DEVELOPMENT FACILITATION TEAM

DRB Project Number: 2020-004098  
Bridge and 86th

SUBJECT: Sketch

**Project Name:** Bridgepoint Subdivision

DETAILS 2

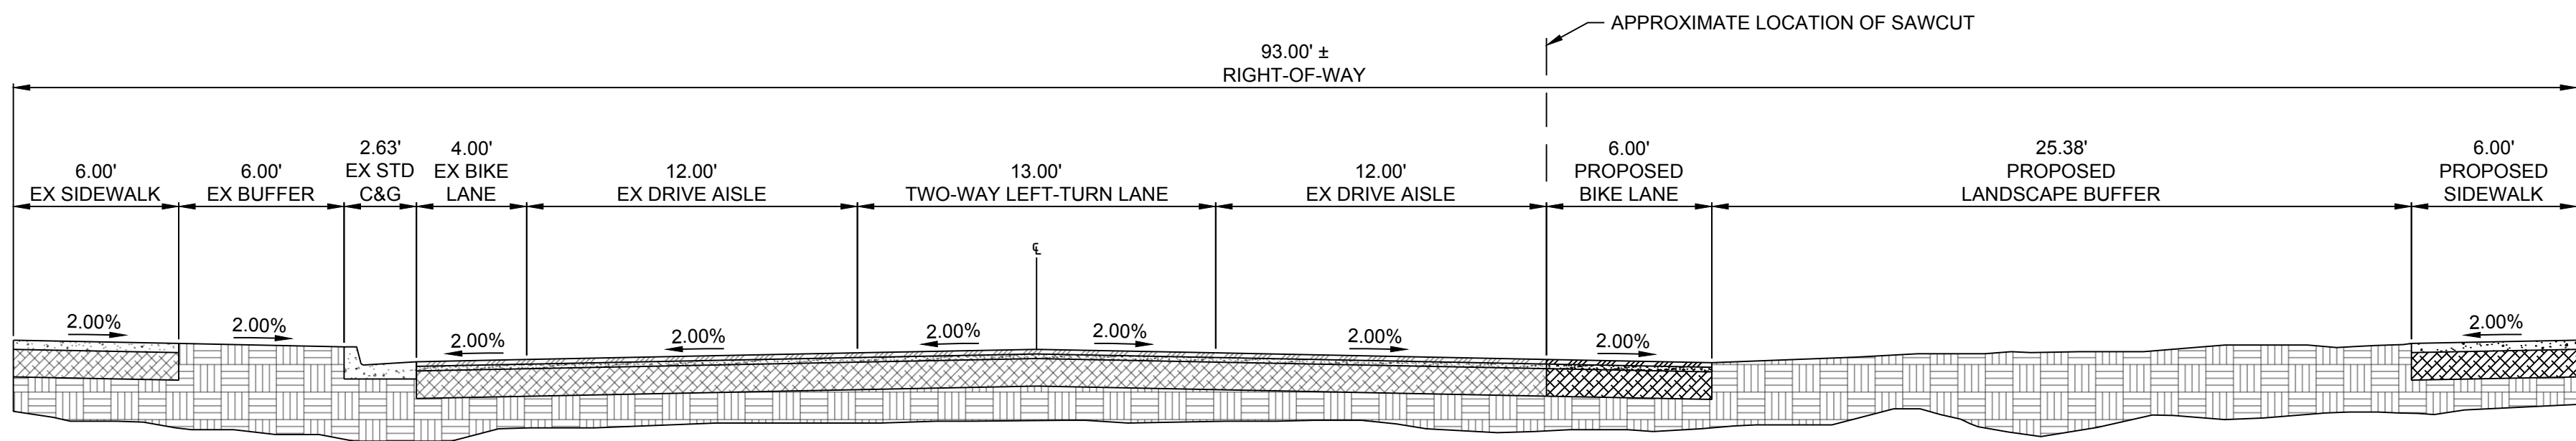
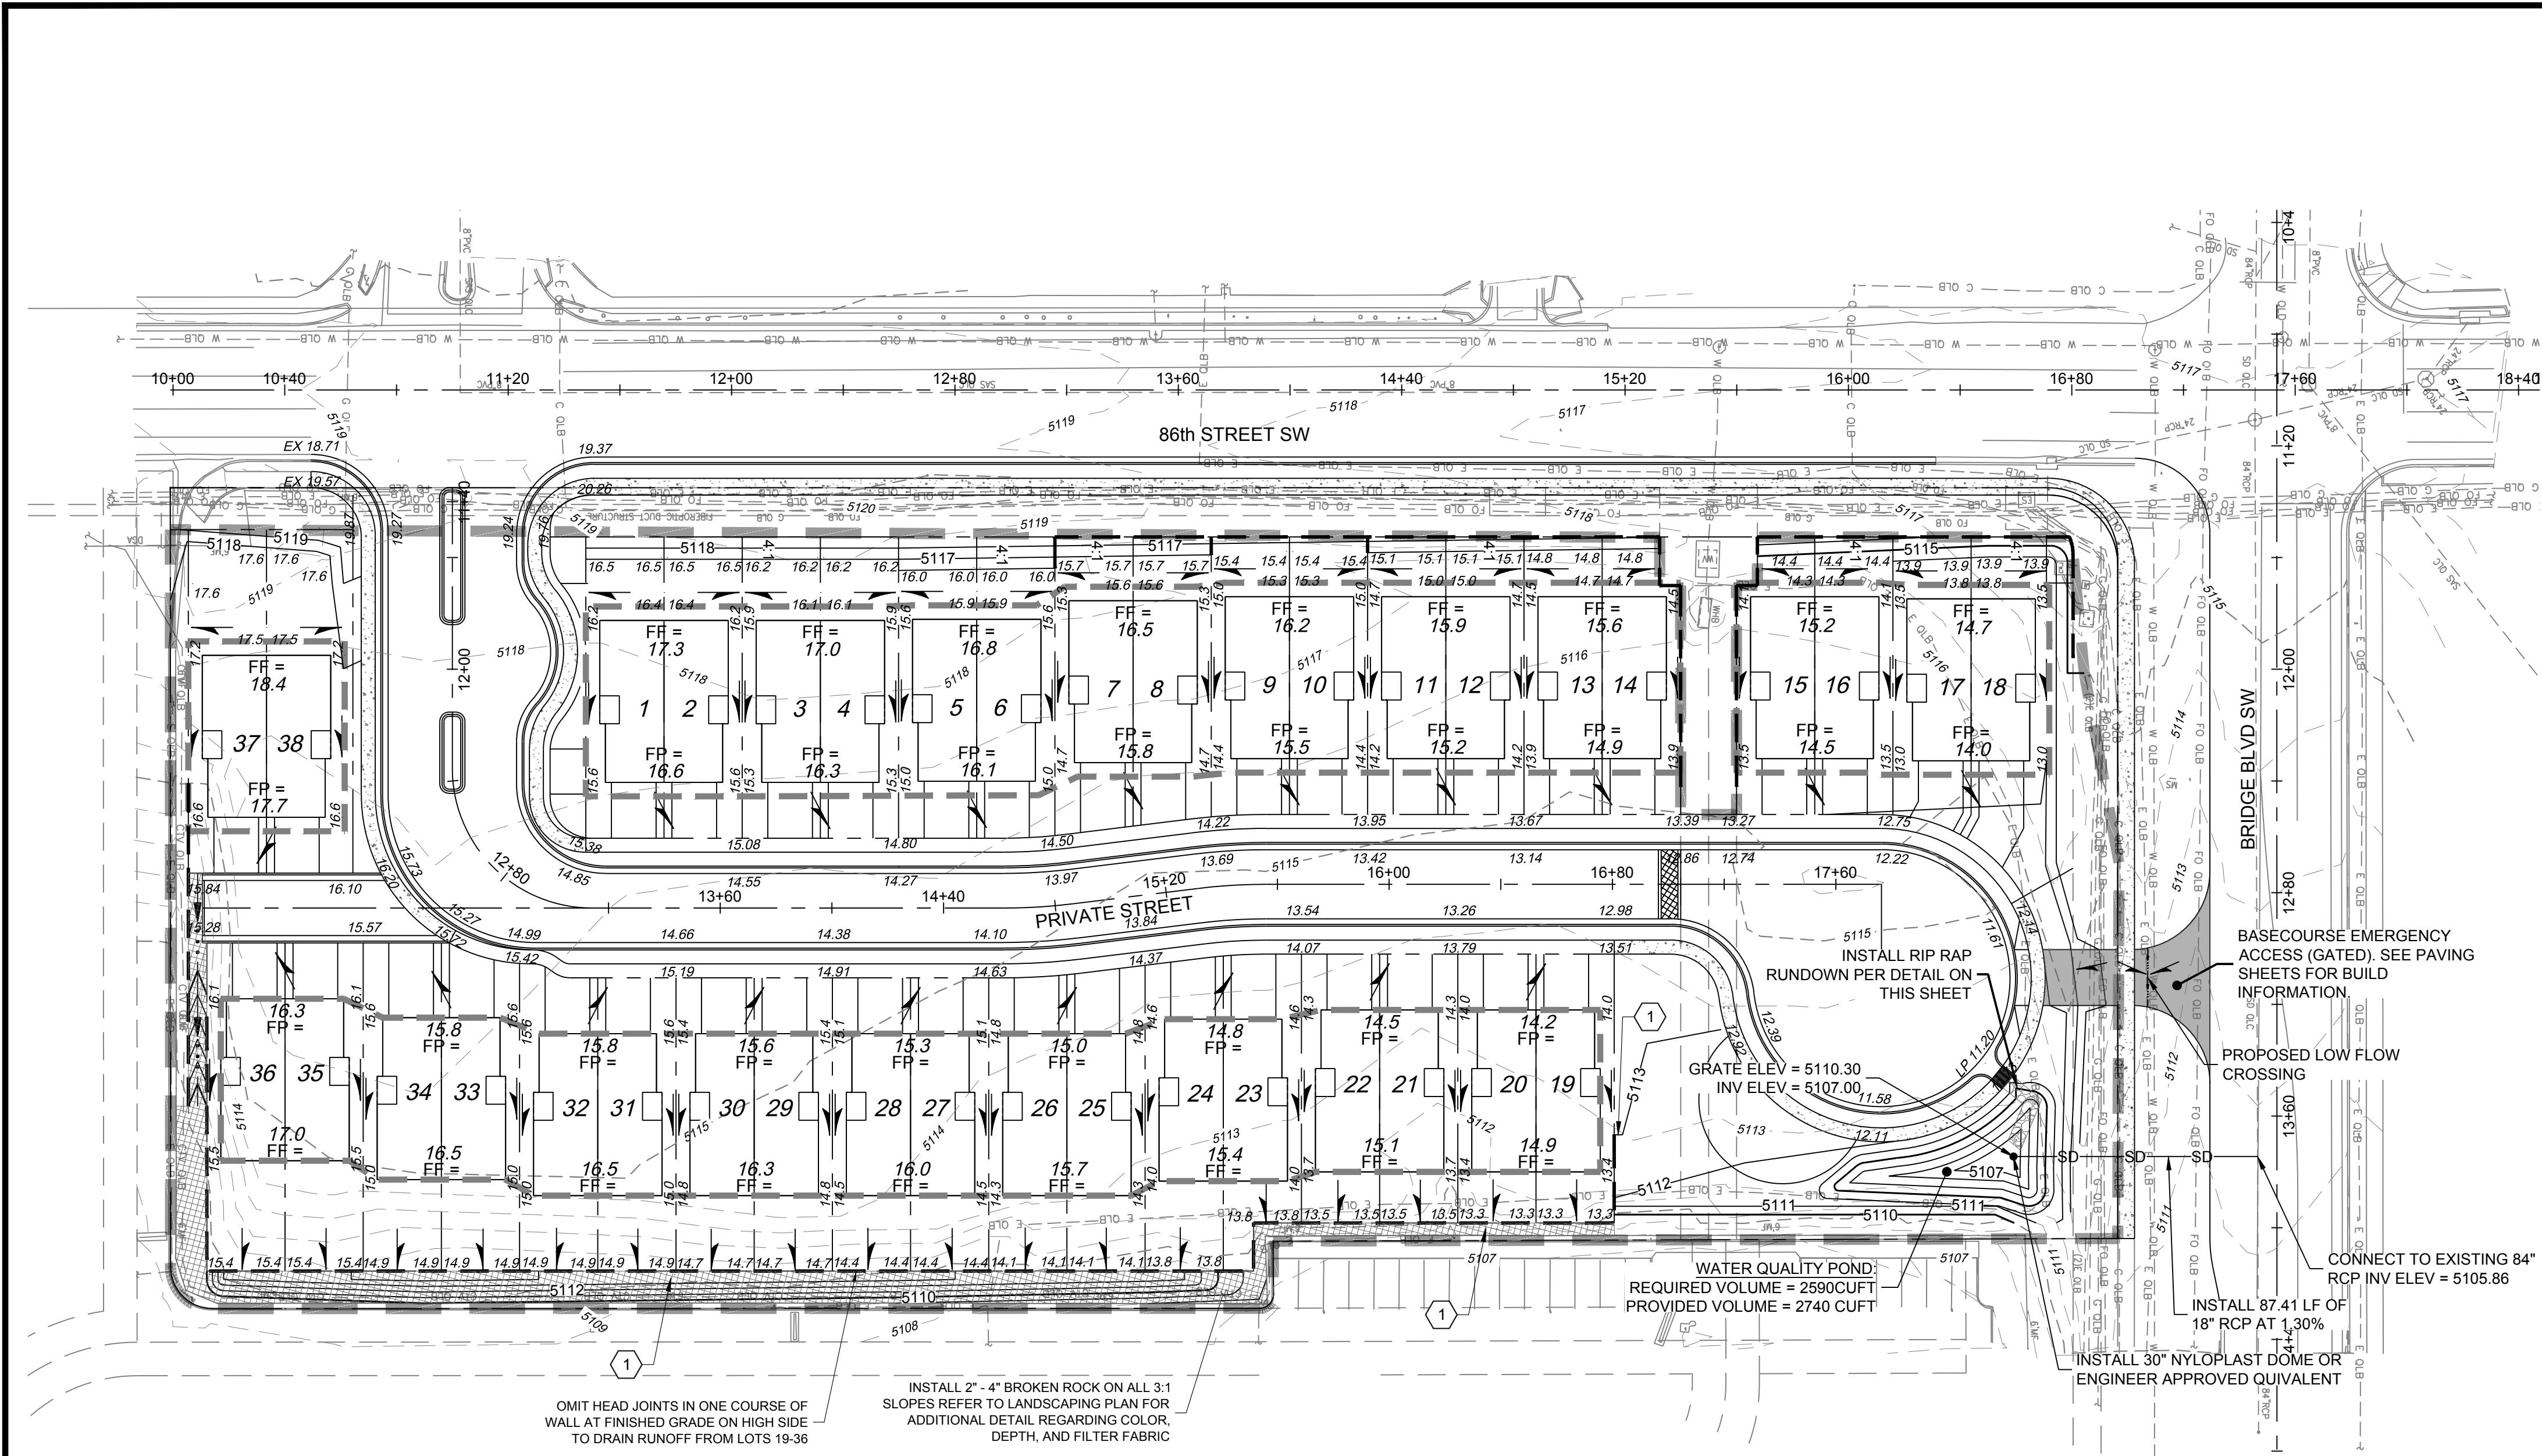
1. Bridge and 86th are both major collectors and require 6' sidewalk with a 5' to 6' landscape buffer.
2. Please list ROW width along both roadways to ensure they meet the requirements of the DPM. There are also proposed bike lanes along Bridge. Please provide a cross section showing if proposed bike lanes will fit within the existing ROW, otherwise ROW dedication may be required.
3. An approved TCL will be required prior to site plan. Please also submit a filled in Traffic Scoping Form to Curtis Cherne ([ccherne@cabq.gov](mailto:ccherne@cabq.gov)) to determine if a TIS will be required.

- \*Please confirm ROW development detail and the compliance of section 7 of the DPM, Table 7.2.29. In regards to Sidewalk width requirements and its landscape buffer.**  
86<sup>th</sup> Street and Bridge are both Major Collectors, Outside of a Center.  
Each requires a **6-foot sidewalk and 5-6' landscape buffer is required.**
